**OXFORDSHIRE COUNTY COUNCIL'S RESPONSE TO CONSULTATION ON THE
FOLLOWING DEVELOPMENT PROPOSAL**

Application no: 14/01888/F

Proposal: Erection of three, two bed apartments over two retail units and a surgery and erection of two, two bed apartments over three retail units and a surgery.

Location: OS Parcel 6920 East of Oxford Road and adjoining and South of Canal Lane, Bodicote

Title
**Planning Application 2:
 Surgery, Retail and Apartment
 Buildings**

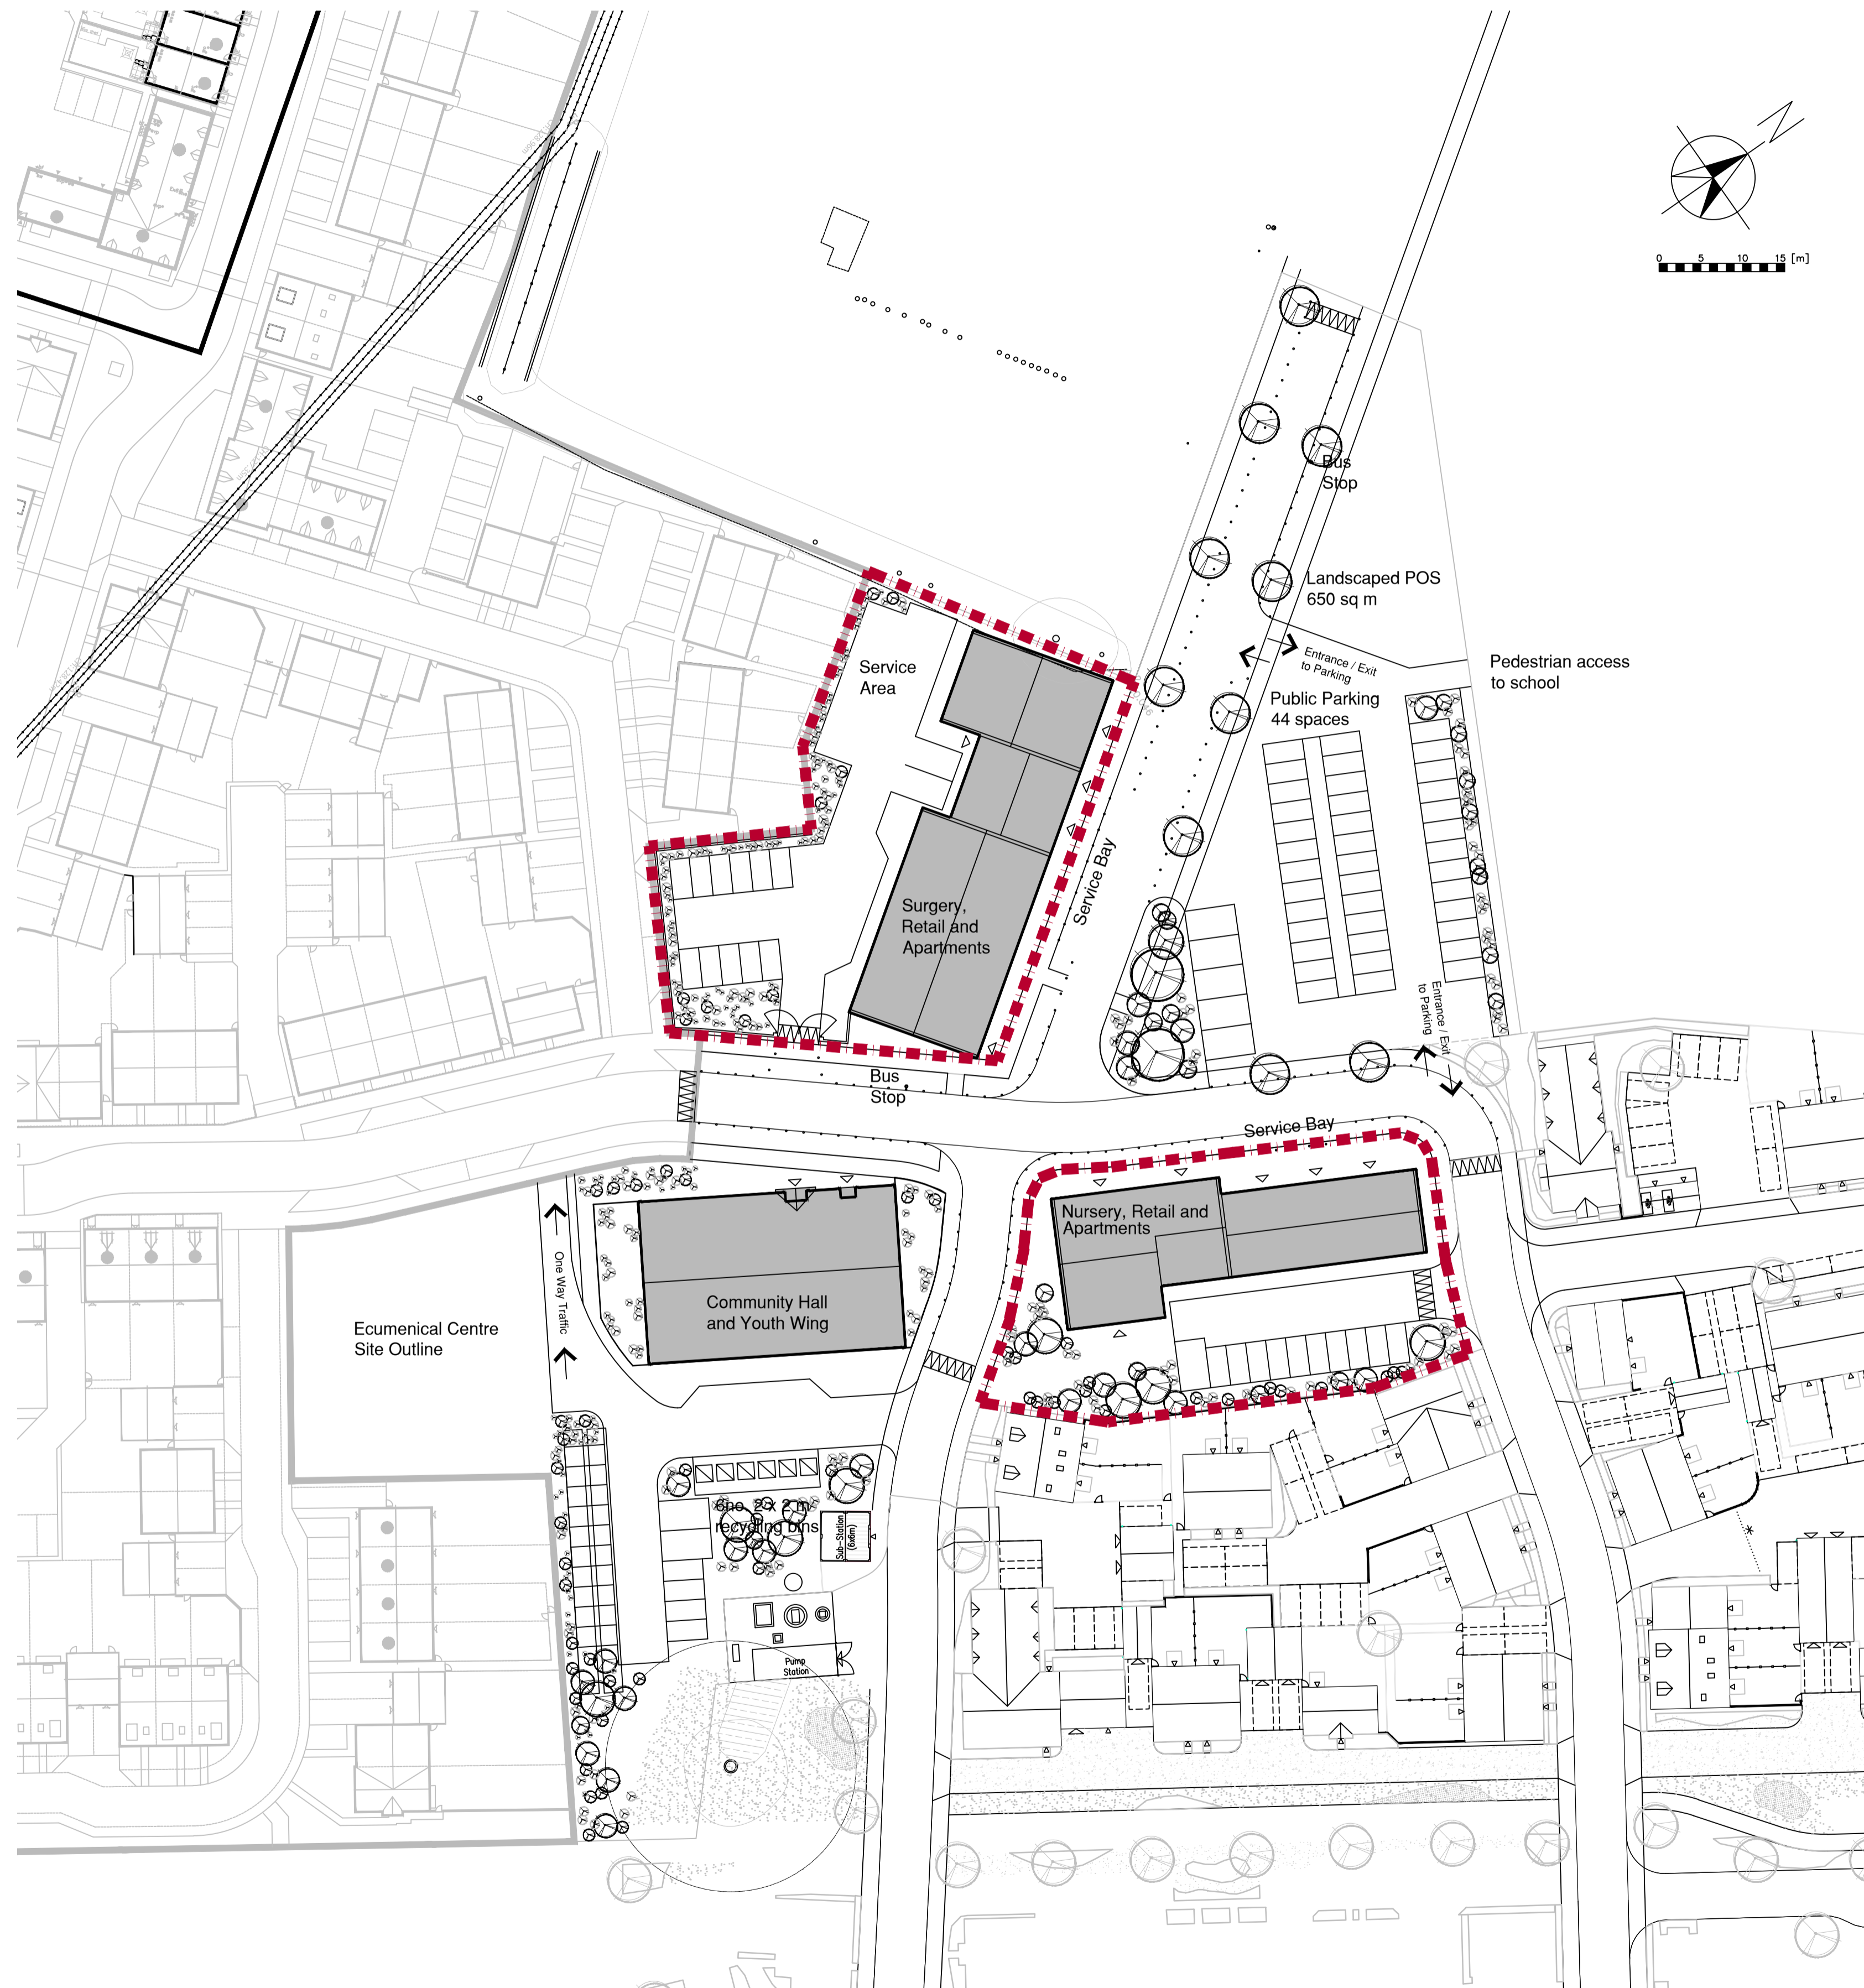
- Carriageway Layout is different to that of the latest Longford Park Planning Layout drawing no.0476-102-12 Revision G
- The access points are located in the incorrect location as per the drawing no.0476-102-12 Revision G
- No vehicle tracking shown for servicing vehicles
- Servicing should not be taken from the Primary Routes within the development
- The residential units require allocated parking this has not been demonstrated
- No cycle parking provision has been demonstrated for the proposal
- Refuse storage has not been demonstrated
- It is unclear whether the parking spaces meet minimum dimensional standards
- No Drainage details have been submitted which has been noted by our Drainage Team
